**Addendum No. 1**

RE: Contract # C204204

**Wake County (P-5720)**

GRADE SEPARATION OF SR-2006 (DURANT ROAD) OVER CSX S LINE  
RAILROAD IN RALEIGH

PROJECT REFERENCE NO.	SHEET NO.
P-5720	EC-8/CONST.5
RDW SHEET NO.	
ROADWAY DESIGN ENGINEER	HYDRAULICS ENGINEER

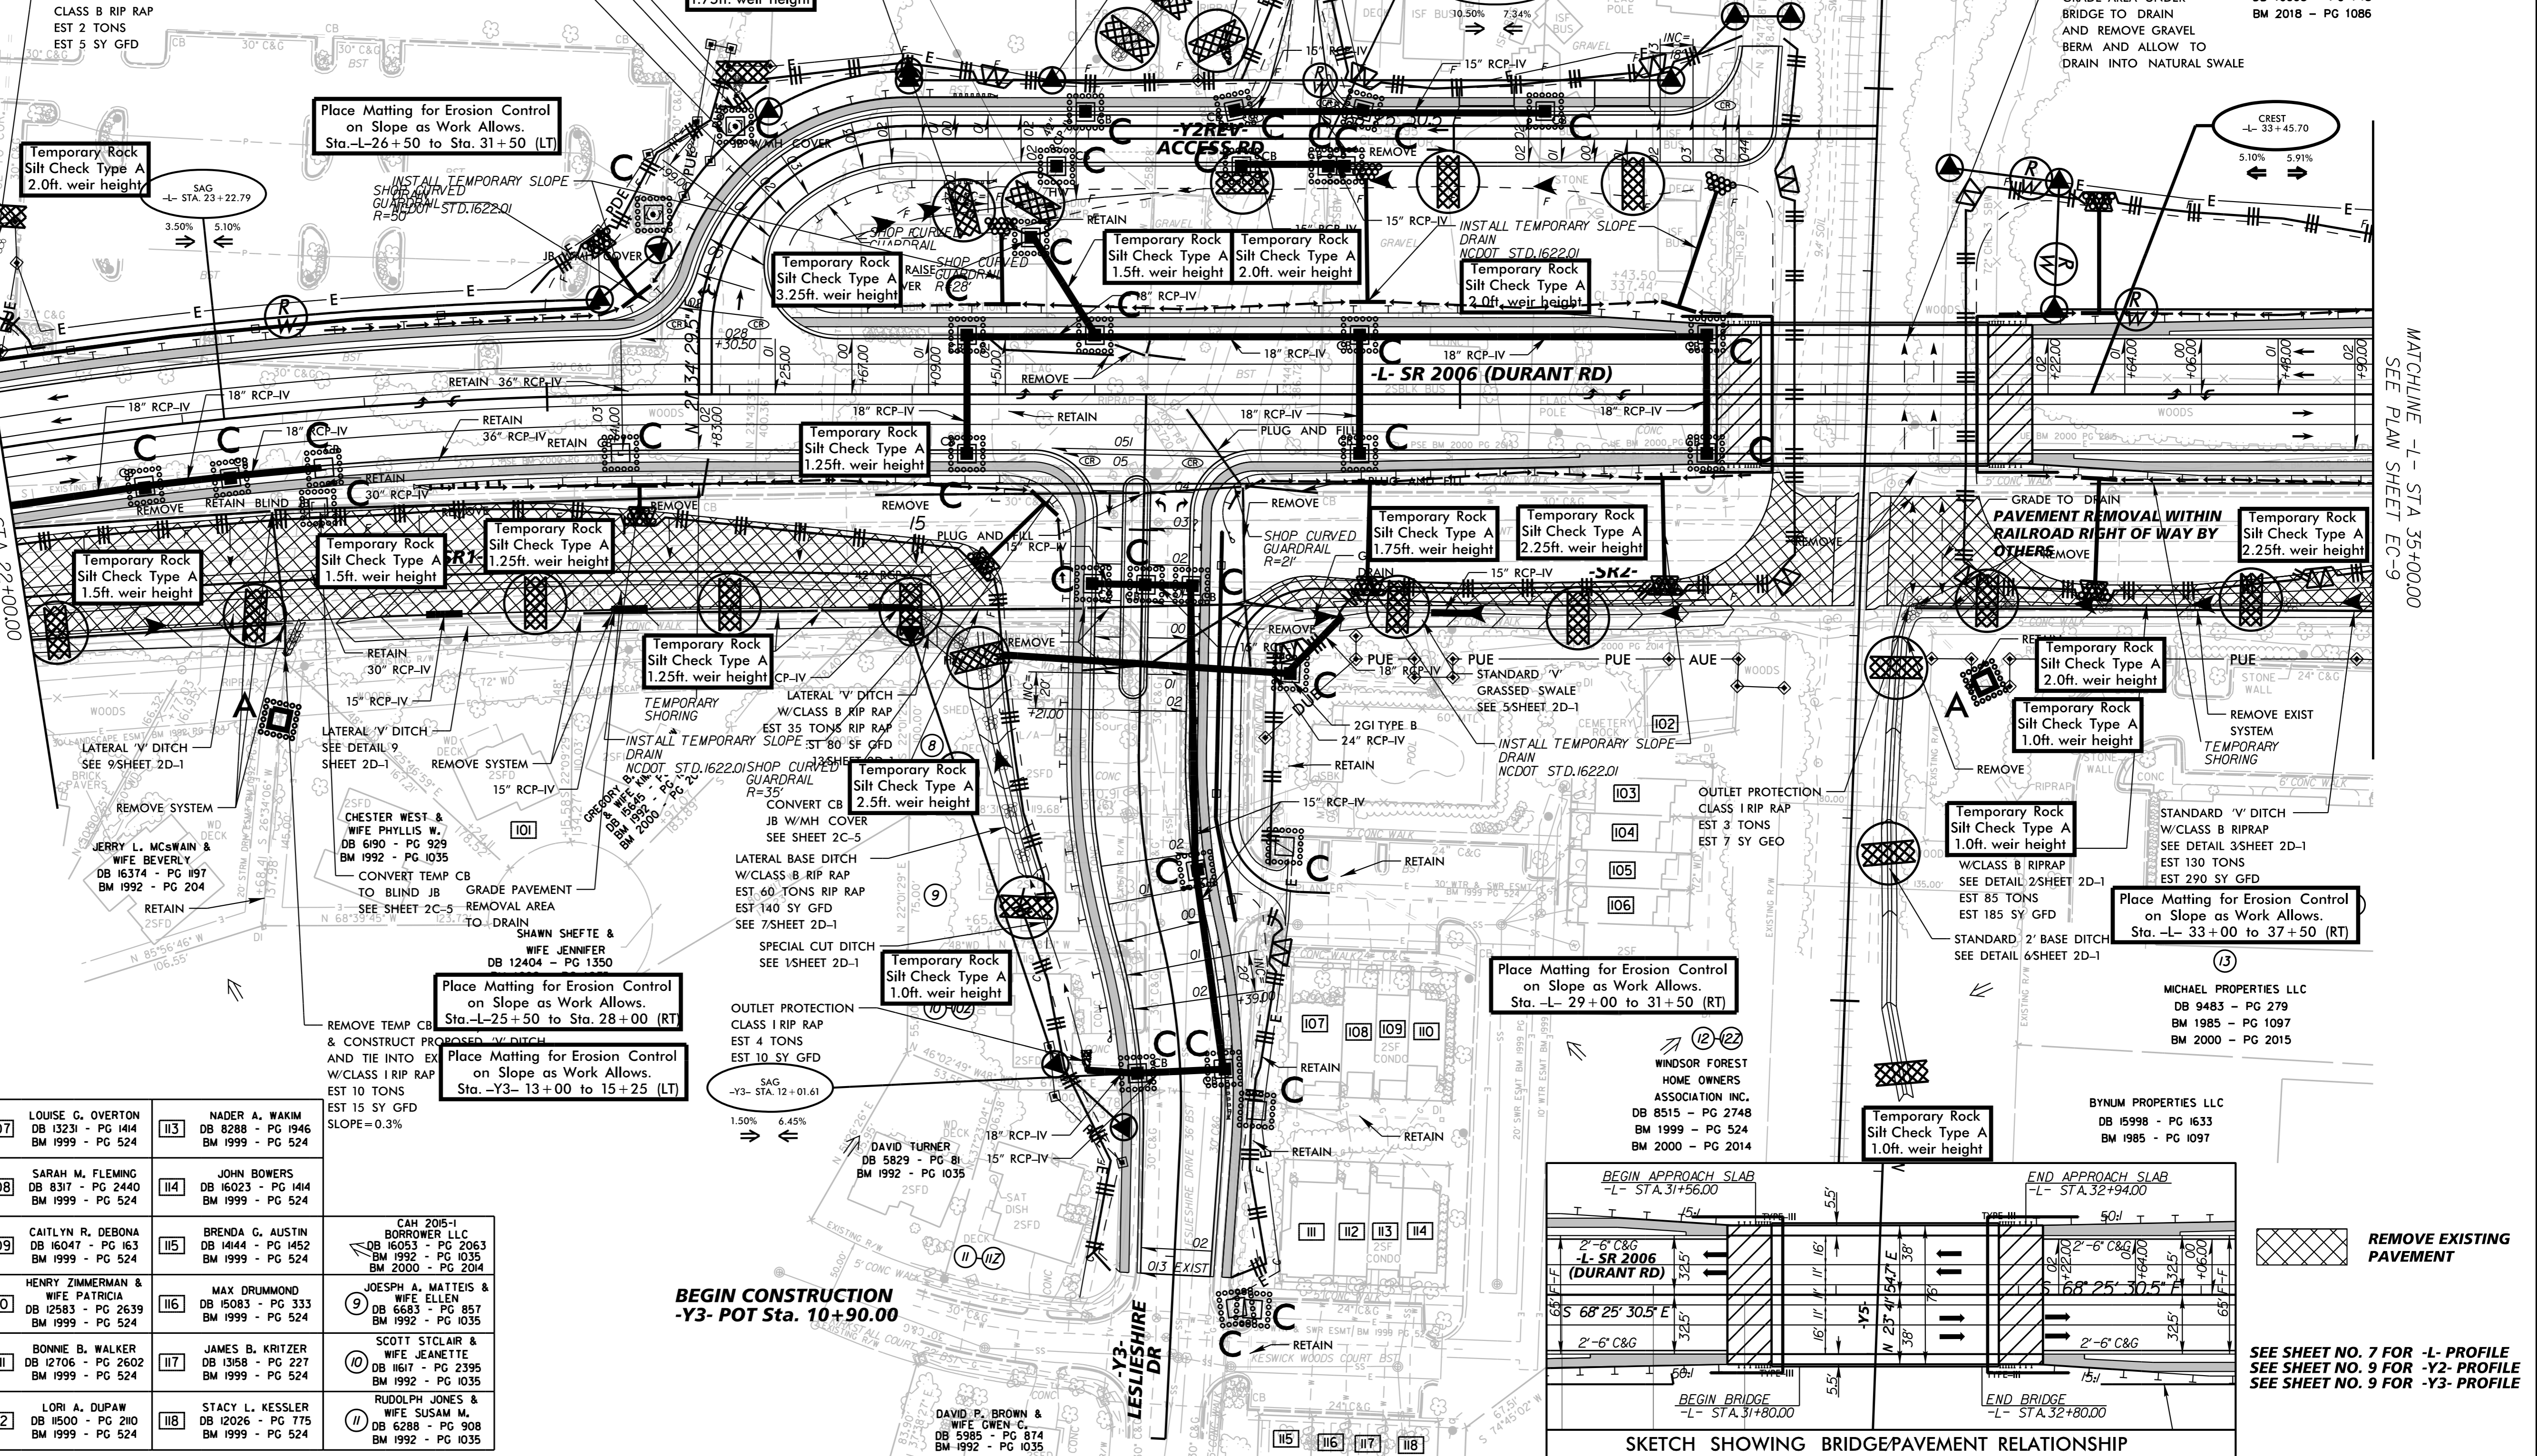
Sheet No.	Revision
1	Letting date updated.
5	Drainage layers cut on to show missing drainage items. Updated sheet should be reviewed for drainage items and notes.

REVISIONS					SHEET NO. S-1
NO.	BY:	DATE:	NO.	DATE:	
1			3		TOTAL SHEETS
2			4		33

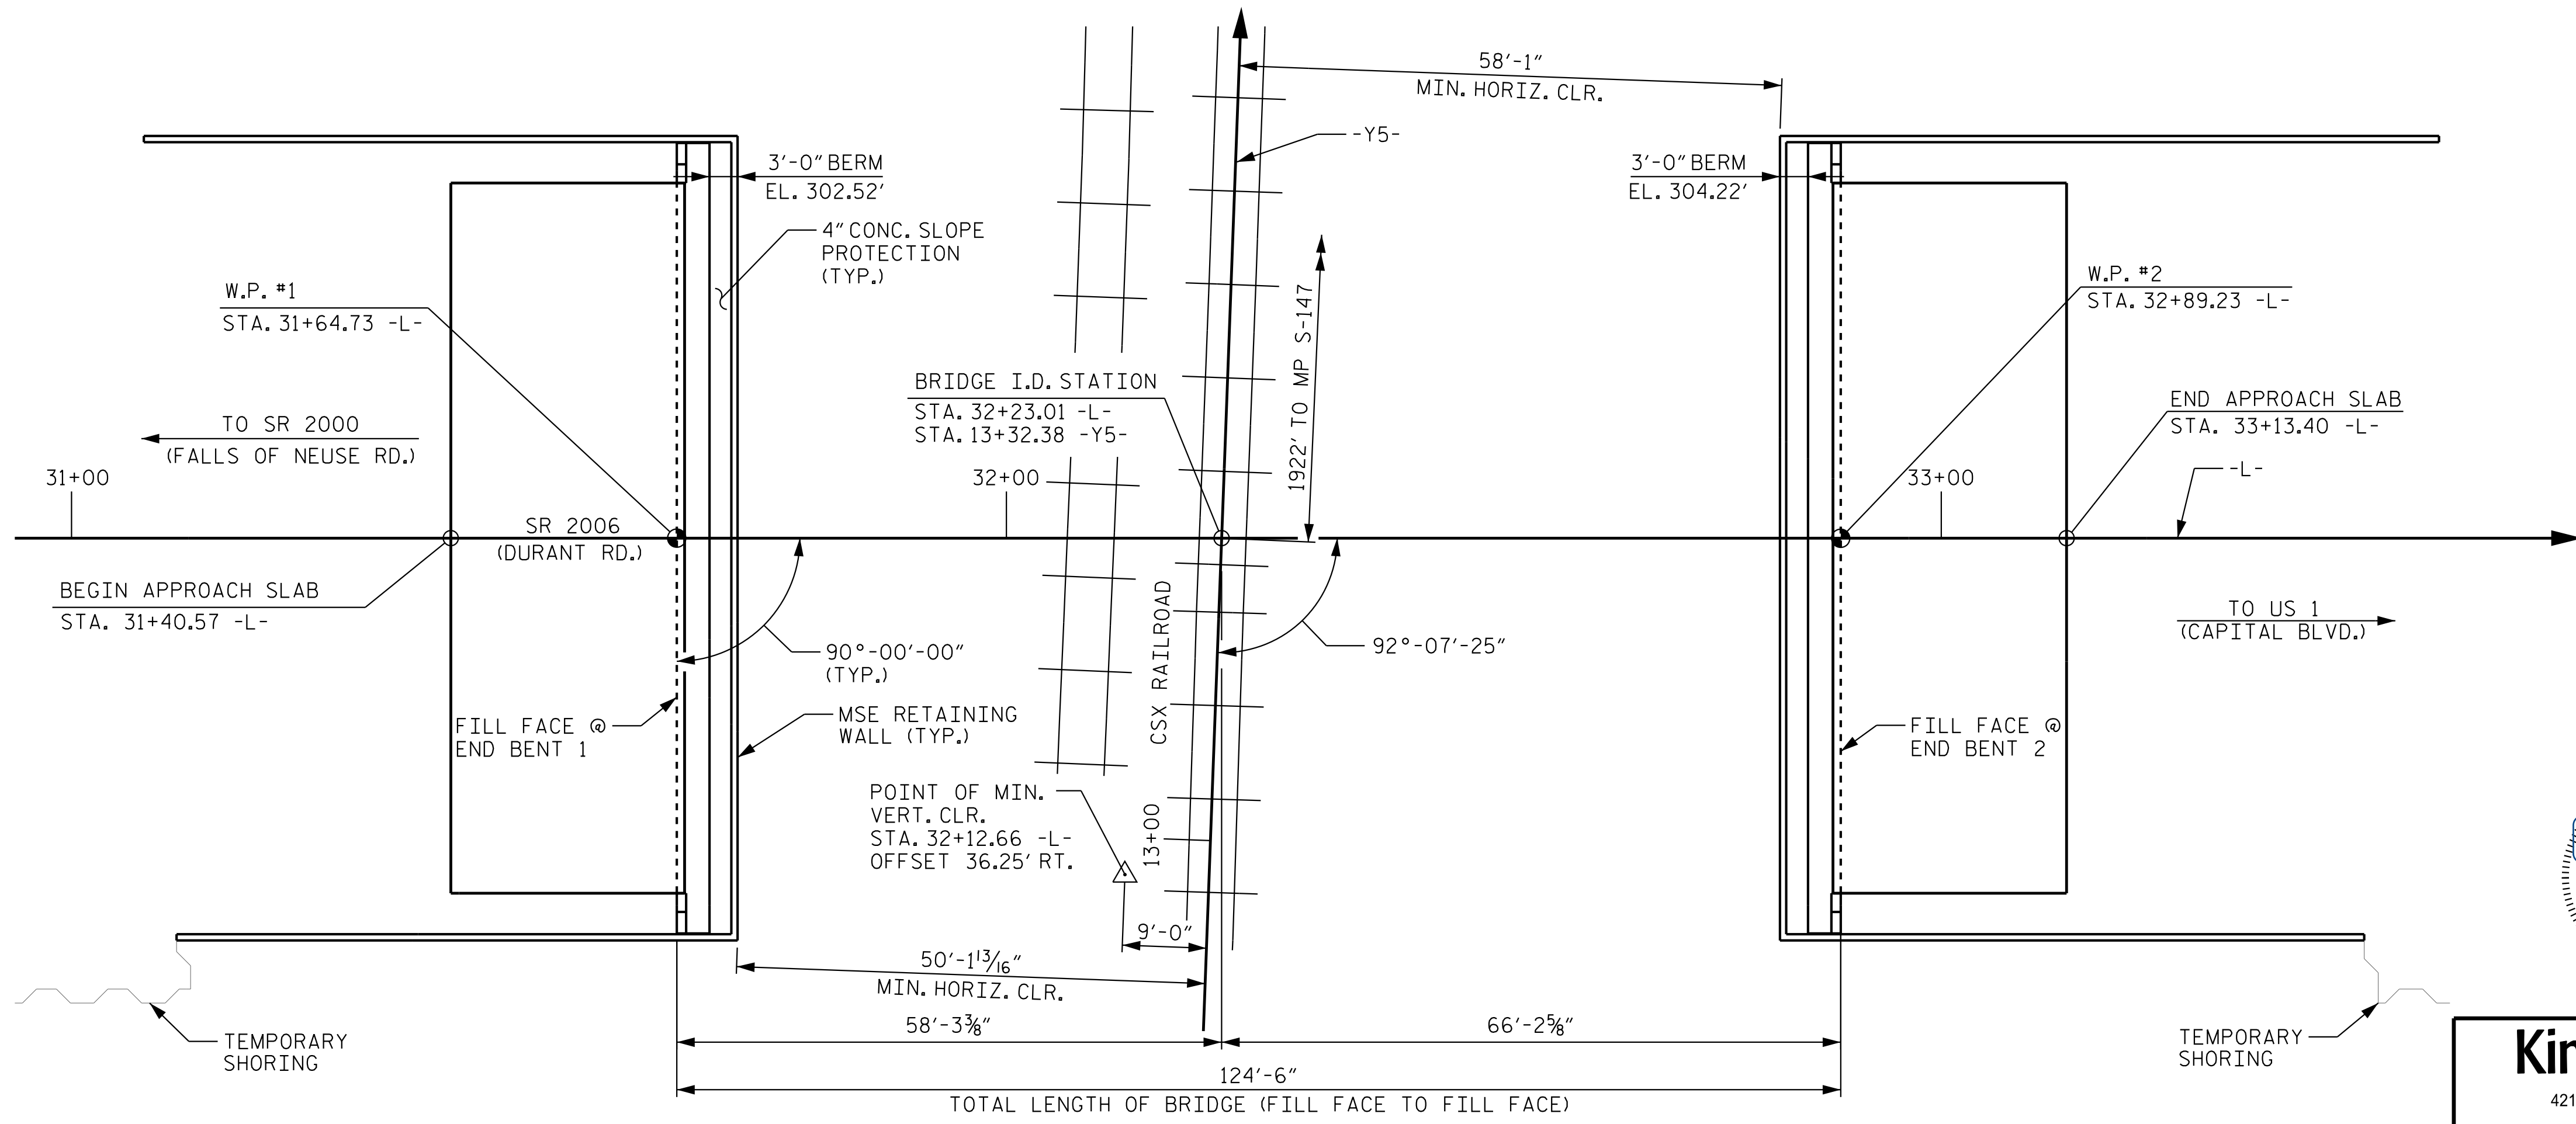
Sheet No.	Revision
Structures Title Sheet	Letting date updated.
S-1	Updated berm elevations.
S-2	Updated geotechnical notes.
S-2A	Updated foundation table.
S-3	Updated girder pay item, reinforcing steel, and concrete.
S-4	Updated LRFR for revised girder design.
S-5	Updated girder, max. build-up, B3 spacing, and overhang thickness.
